Arun District Council
Arun Civic Centre
Maltravers Road
Littlehampton
West Sussex BN17 5LF
Planning & Building Control General Enquiries
Tel: (01903) 737756 Fax: (01903) 730442
Dx: 57406 Littlehampton
Minicom: 01903 732765
e-mail: planning@arun.gov.uk
website: www.arun.gov.uk/planning

Application No: FG/46/20/PL
Site Address: The Tudor Close Public House Ferringham Lane Ferring BN12 5NQ
Description of works: Conversion of the existing Public House (Class A4) to create 7 No residential units comprising 5 No 1-bedroom units & 2 No 2-bedroom units & the erection of 2 No 2-bedroom semi-detached chalet bungalows with associated car parking & landscaping. This application may affect a Public Right of Way.

Thank you for your internet representation made on 25th May 2020 which has been recorded as an objection with the comments as follows:

Drawing Title:
Elevations
As Proposed

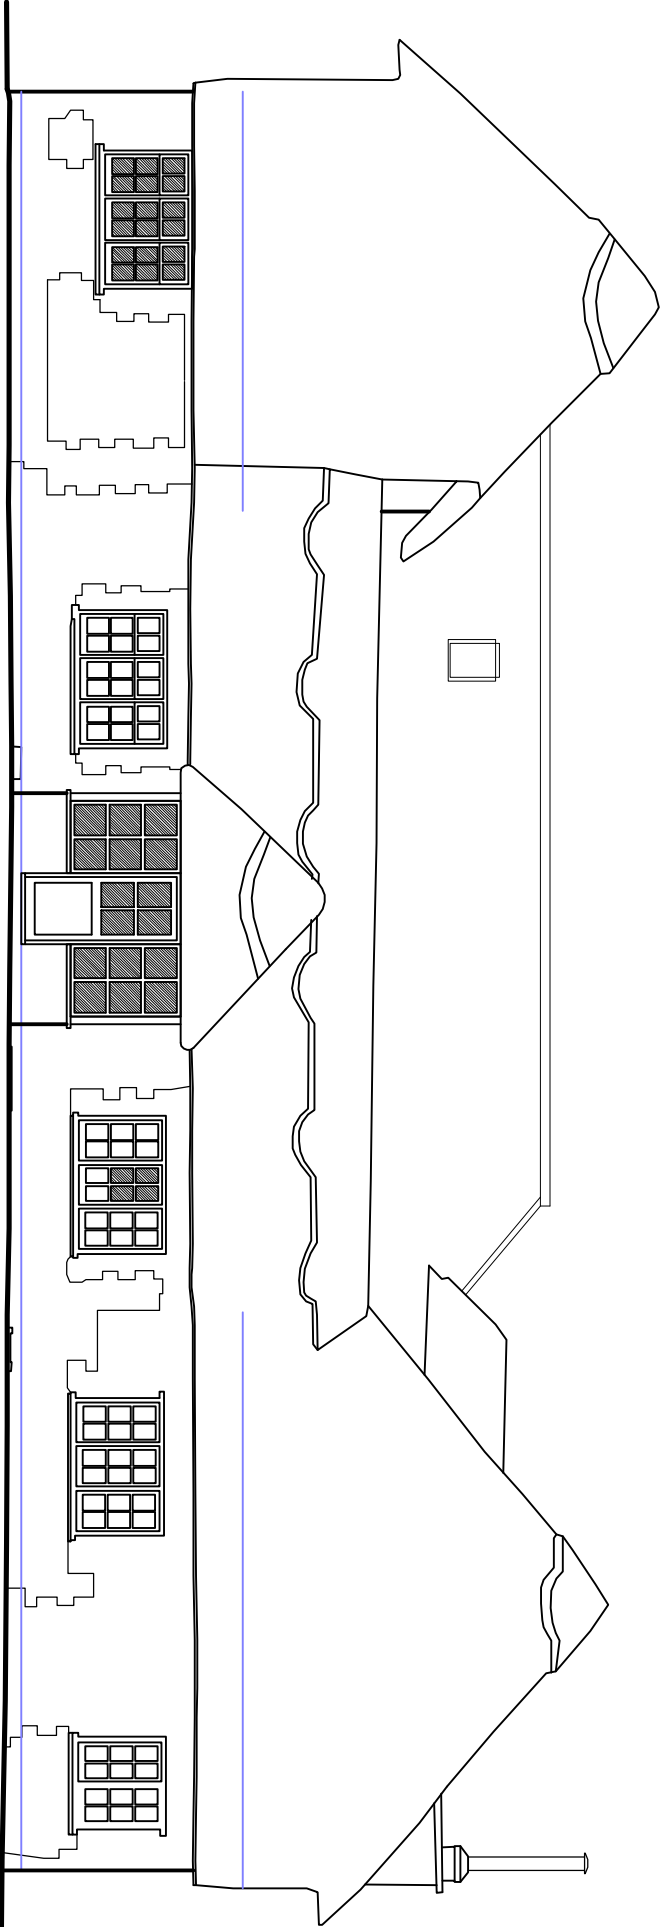
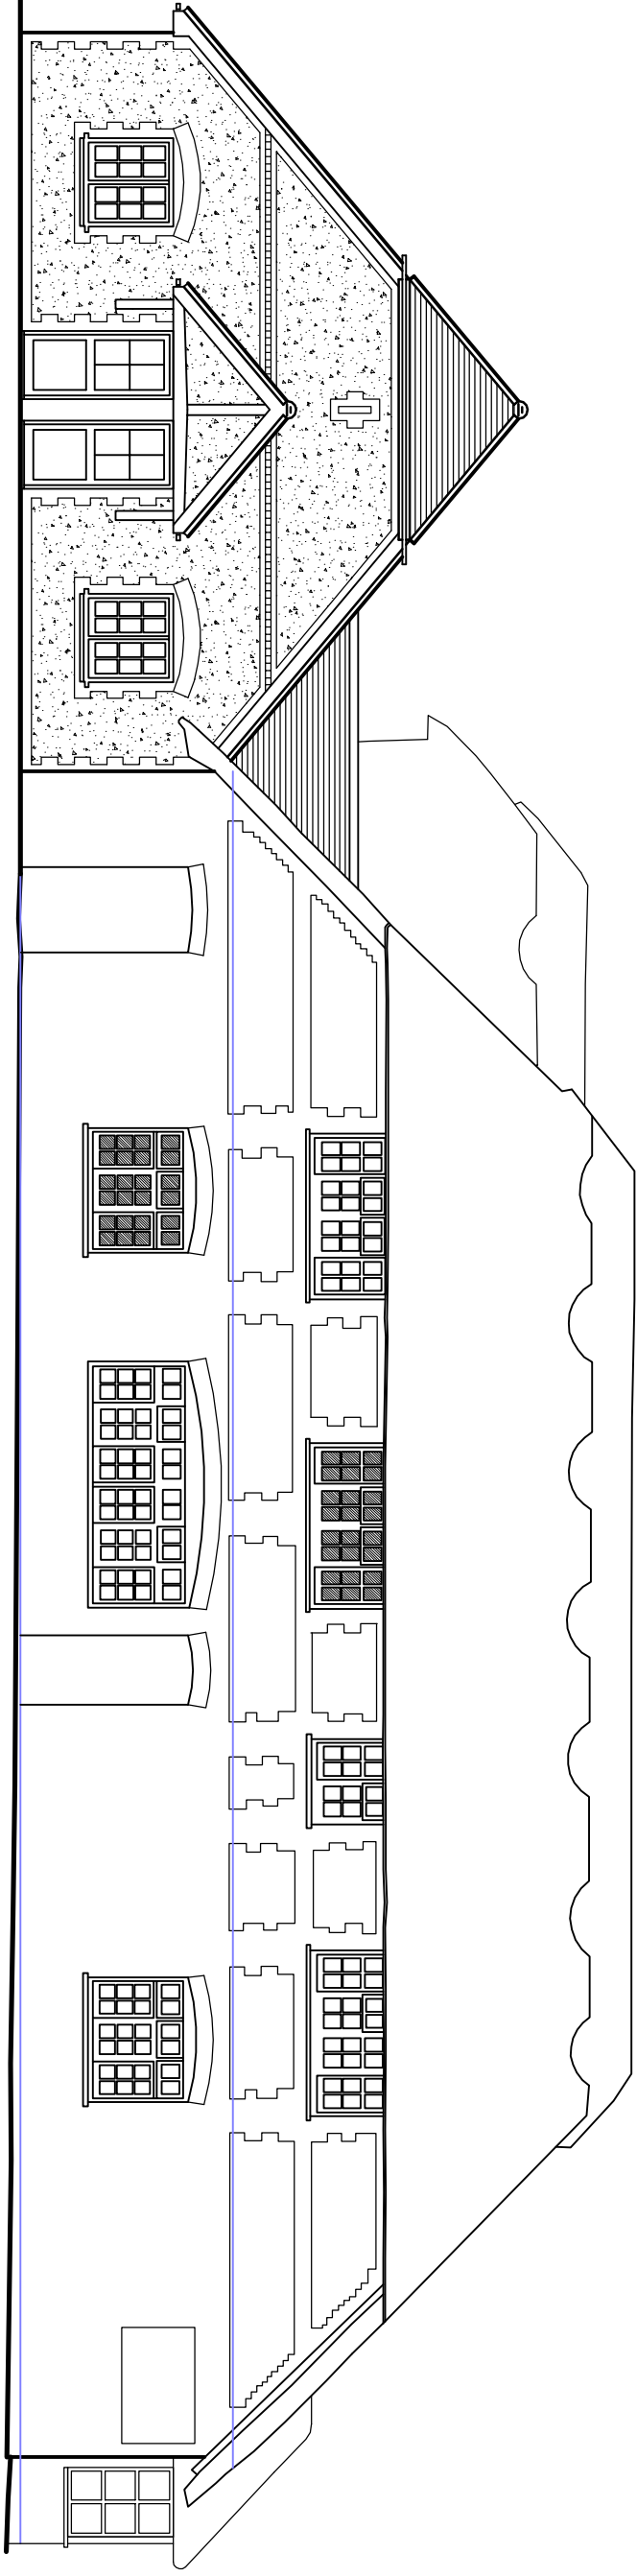
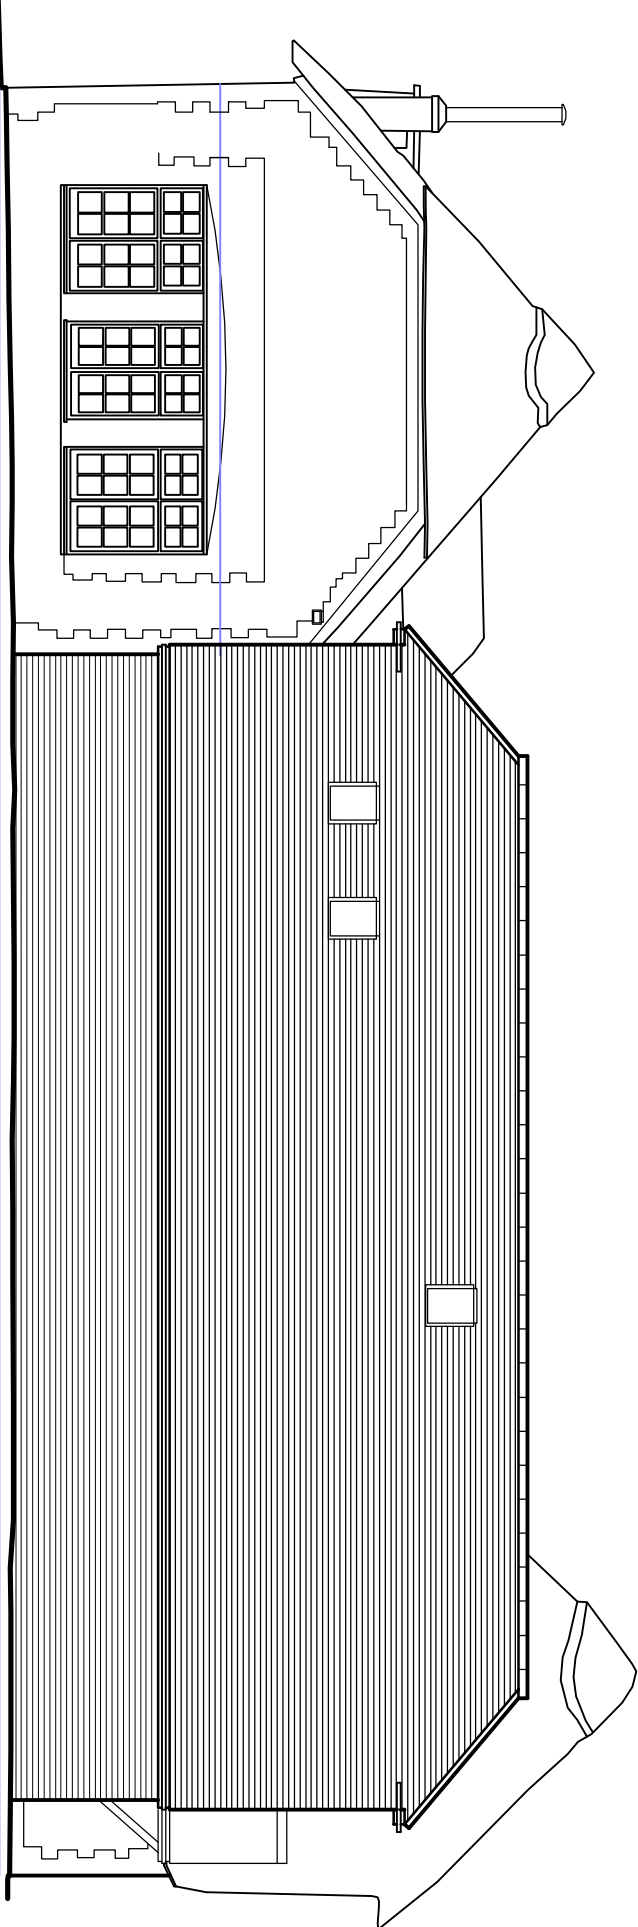
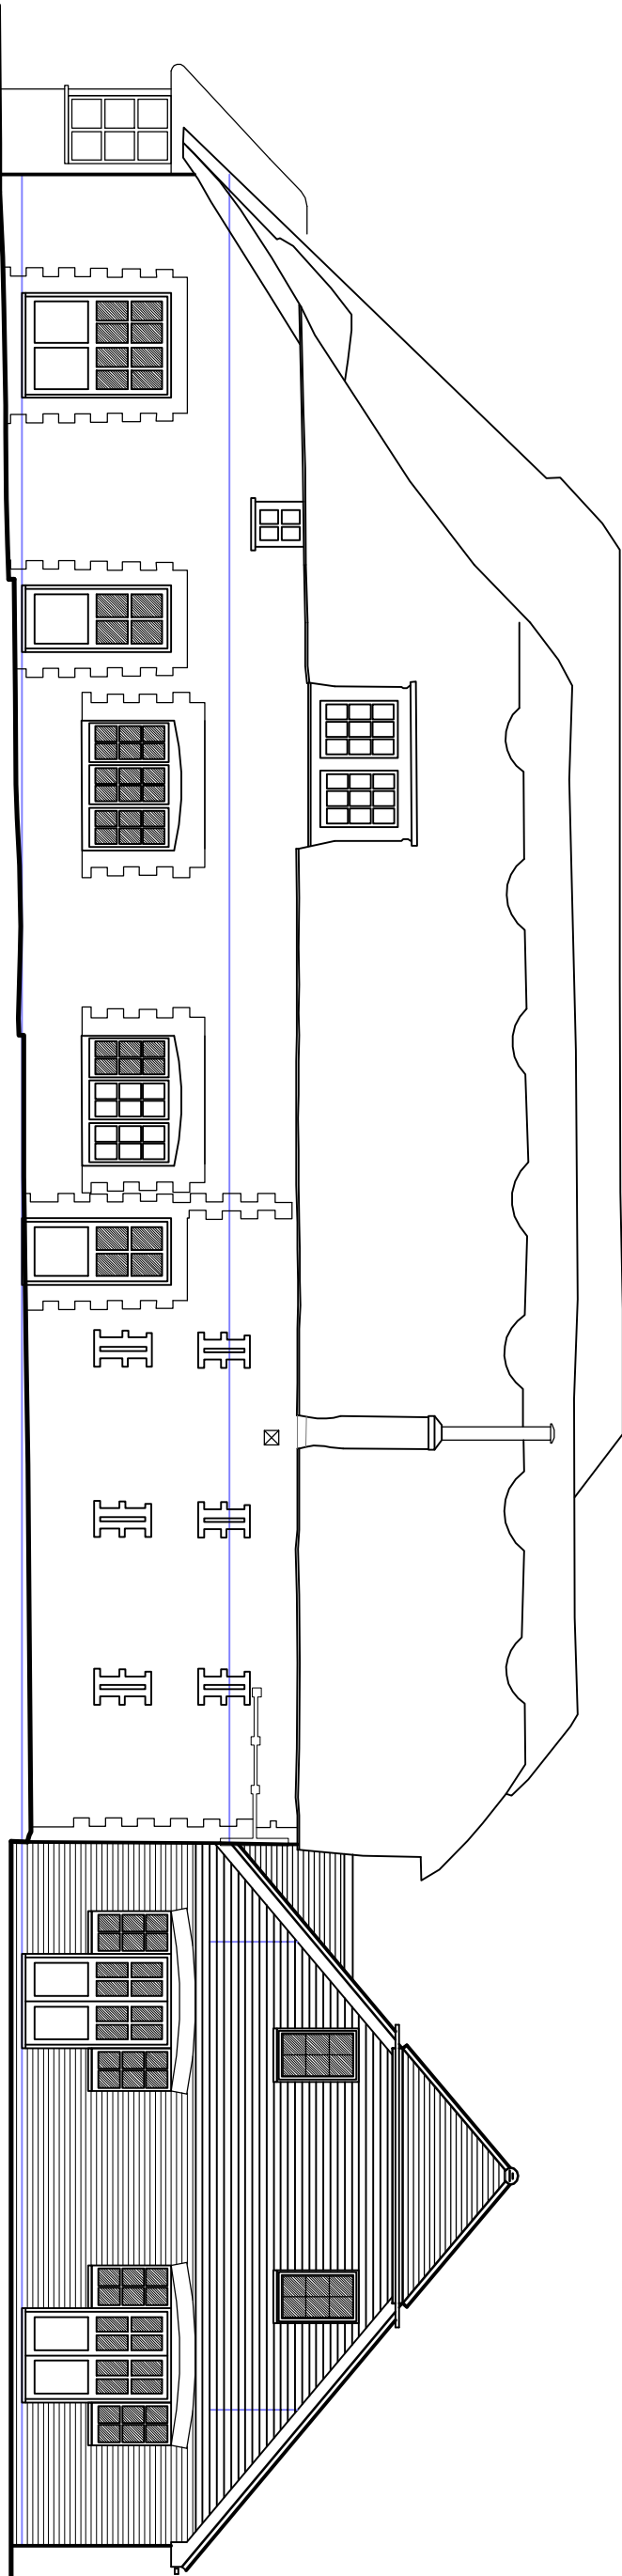
I object to this application on two grounds. First, the addition of two semi-detached properties at the rear of the existing building is at variance with the main building and would dominate the view of the properties in Garden Close. Secondly, the existing Public House is one of character that helps give south Ferring its heart and any alterations are contrary to the aim of the Local Plan that attaches value to Locally listed Buildings. Other considerations are the impact on local parking with limited space available. I implore the Council to refuse this application. I would hope the owners can see fit to continue with the Public House - we need it in this part of Ferring!
